CITY OF PORTLAND, MAINE
DEVELOPMENT REVIEW APPLICATION
PLANNING DEPARTMENT PROCESSING FORM

Lot #12 Haskell St.

From: Jay Reynolds
To: Doug Reynolds
Date: Wed, May 21, 2003 3:24 PM
Subject: 12 Haskell

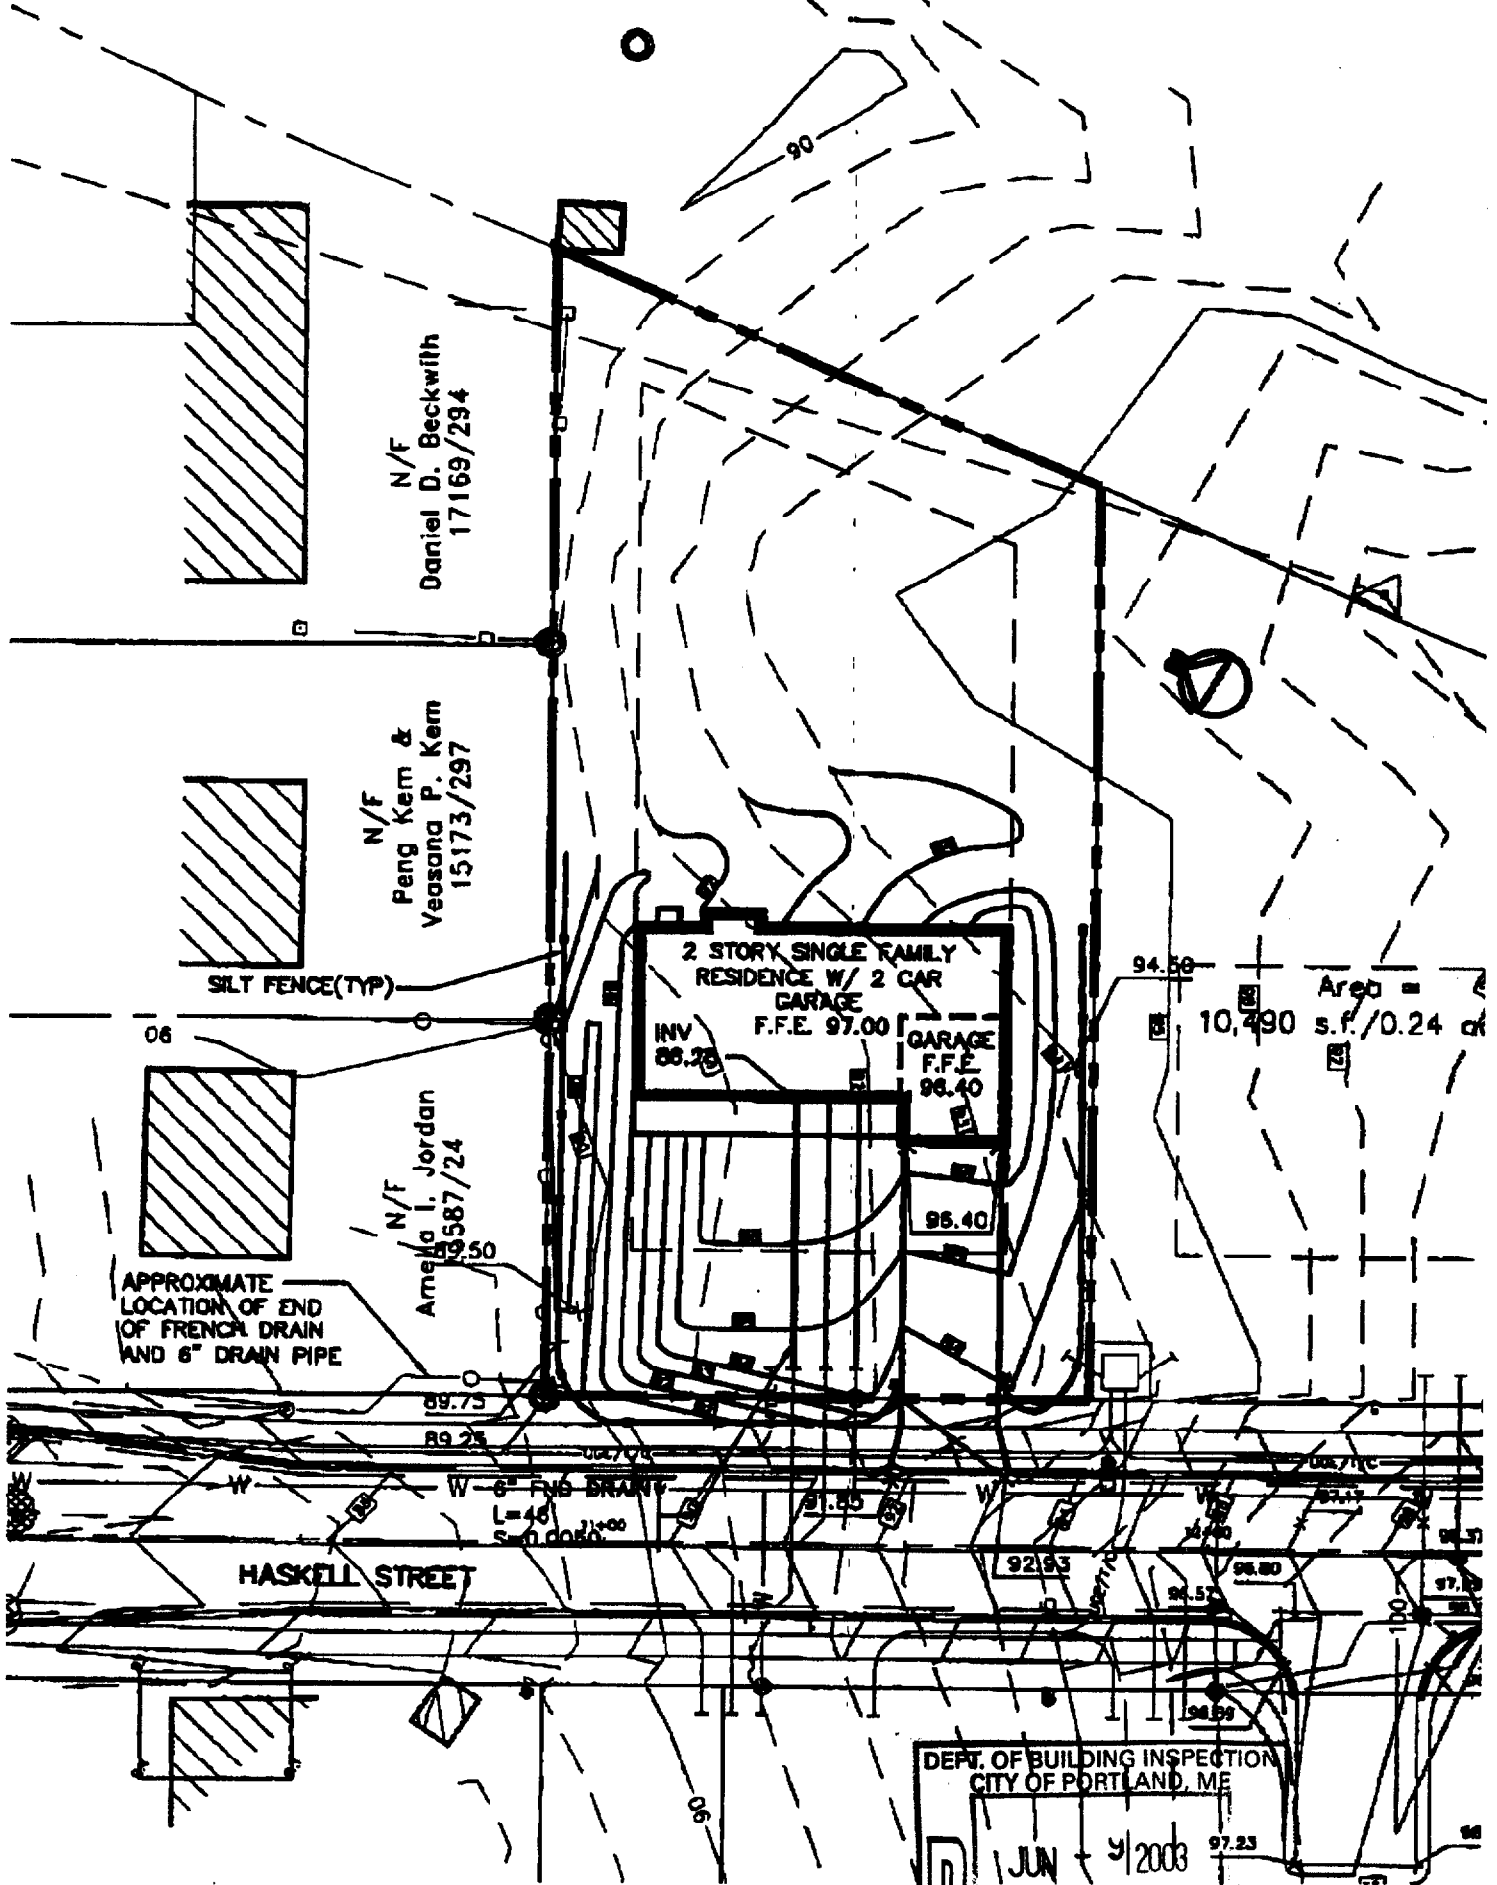
1. There is an errant line on the Adjacent lot. ??
2. Grading and Drainage:

The neighbor on Harris Ave. is concerned about drainage, as am I. The site plan shows a steep drop off in grade, matching in at the property line, pitching towards this property. It appears that the rear of the lot is graded to pitch drainage toward this property also. Like the other side of the street, Mr. Wolf installed a 6" SD lateral to the Property line for drainage purposes. I would like to see this pipe be used, by tying on to it and using it to collect drainage along that side boundary line. (very important).
